**CITY OF PORTLAND, MAINE
DEVELOPMENT REVIEW APPLICATION
PLANNING DEPARTMENT PROCESSING FORM**

5/13/97
Application Date
Park Danforth
Project Name/Description

RE: Park Danforth Site - Erosion Control Progress

**THE PARK-DANFORTH
VICINITY OF 777 STEVENS AVENUE
CONDITIONAL USE, SITE PLAN AND SUBDIVISION REVIEW
THE PARK DANFORTH, APPLICANT**

**EROSION CONTROL PLAN**

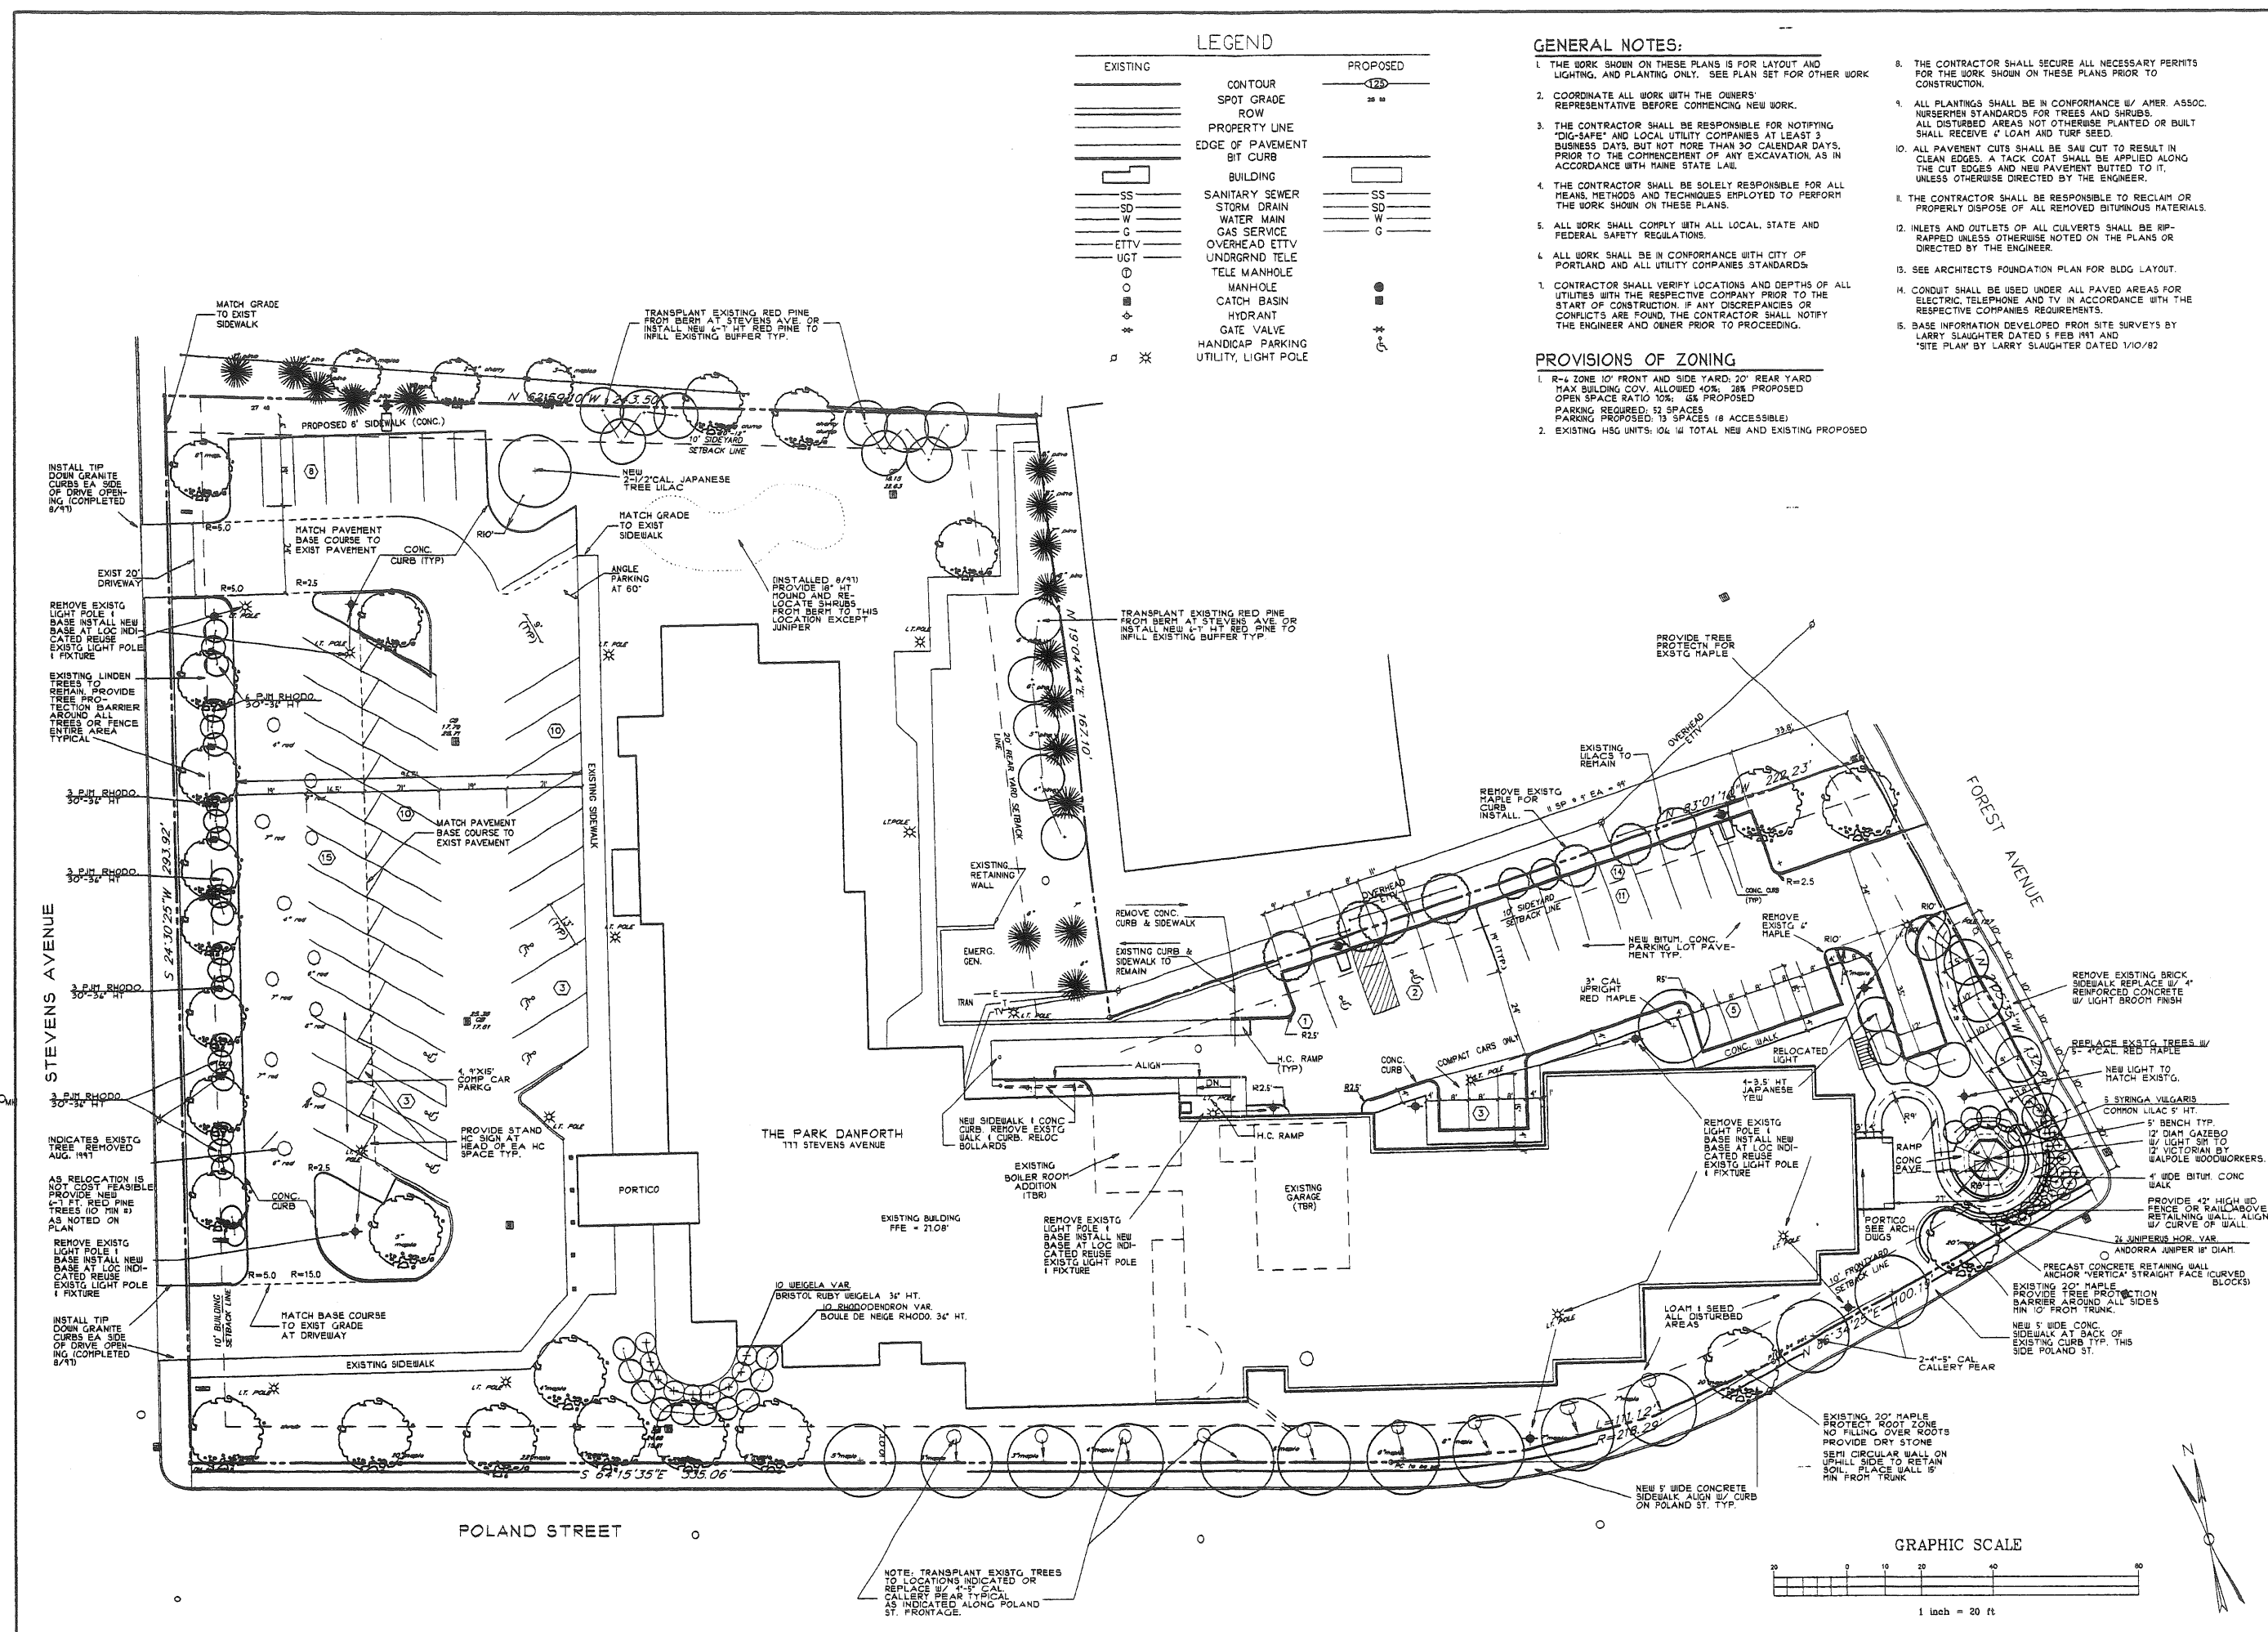
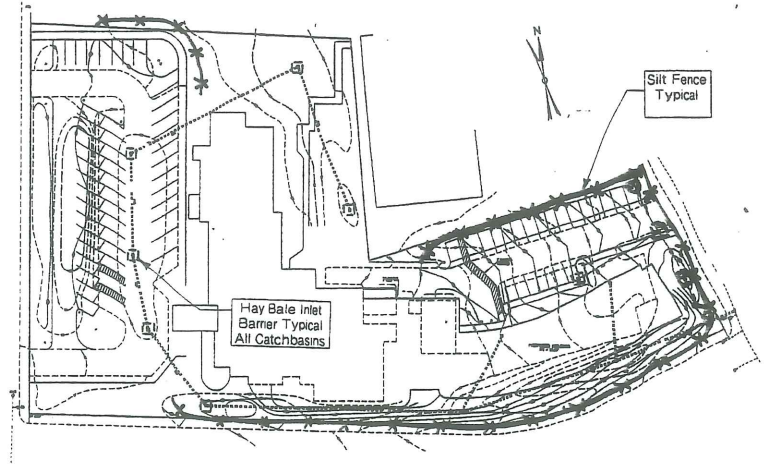
- The silt fence that exists between the retaining wall and the sidewalk that runs adjacent to Forest Avenue has been torn and has fallen down. Repair is needed to the silt fence. There is no means in place at site entrance/exit to Forest to prevent tracking of soils onto roadway, such as a gravel strip. There is no silt fence between the site and Poland Street.
- There is debris on site near the edge of Poland Road.
- Building is fully enclosed; site work completed is minimal.
- Spoke with Scott the foreman on site about erosion and sediment control issues. He said that he would fix the problems.
